Consultation Response from KC, Conservation and Design
2020/90819 The Warehouse, 12, Zetland Street, Huddersfield, HD1 2RA
Advertisement Consent for erection of illuminated LED sign (within a Conservation Area)
Date Responded: 20.5.20
Responding Officer: Sue Oakley
Responding Ref:

ITEM 01 (Qty 1) LED BLUE MANNEQUIN

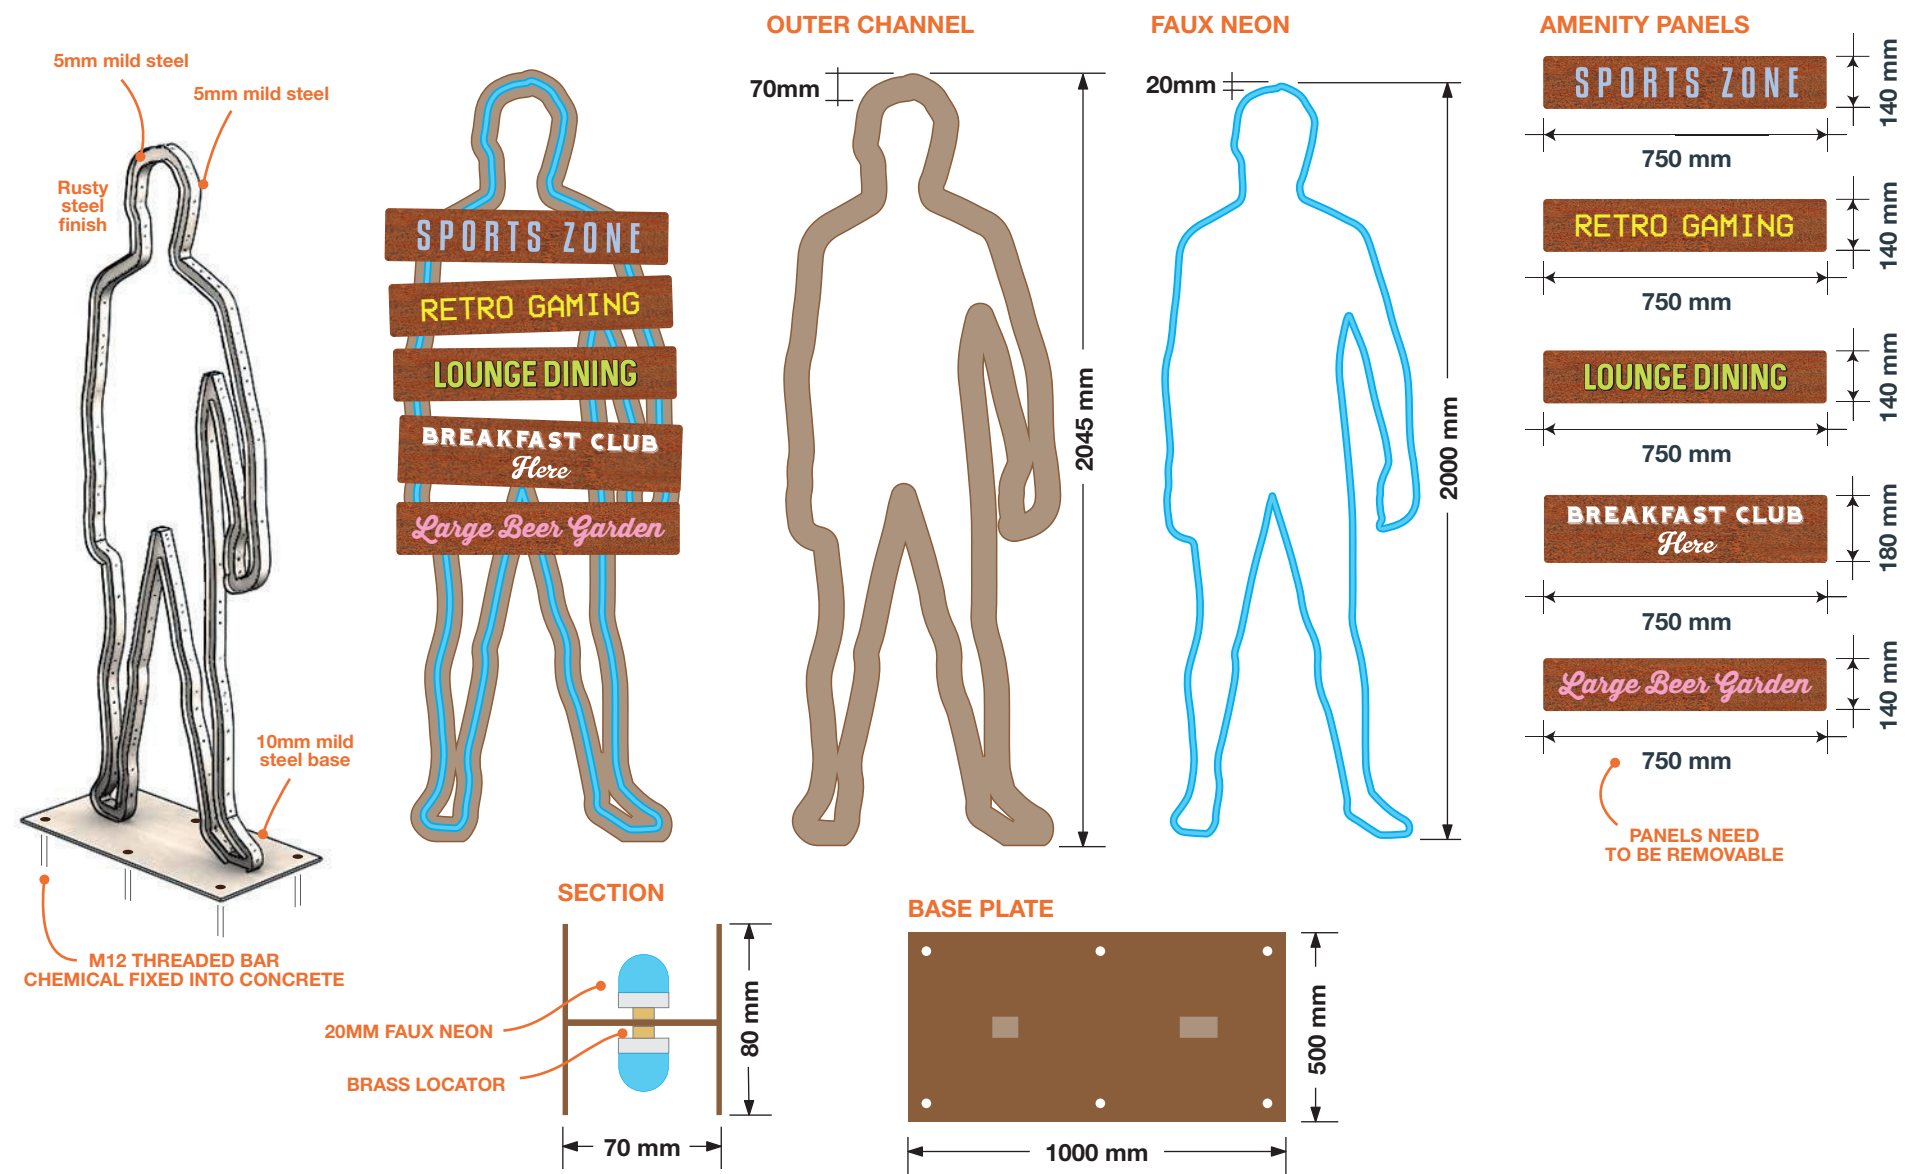
This retrospective proposal is for the erection of a 2m high mannequin with an illuminated blue LED outline and applied plaques, situated on a raised bed around half a metre above ground level at the front boundary of the site.

Although this blue LED sign causes slight harm to the character of the conservation area, I am comfortable that the removal of the previous signage ensures that there is no additional clutter. The slight public benefits of providing roadside signage to advertise the business, which is set back from the road, outweighs the slight harm.
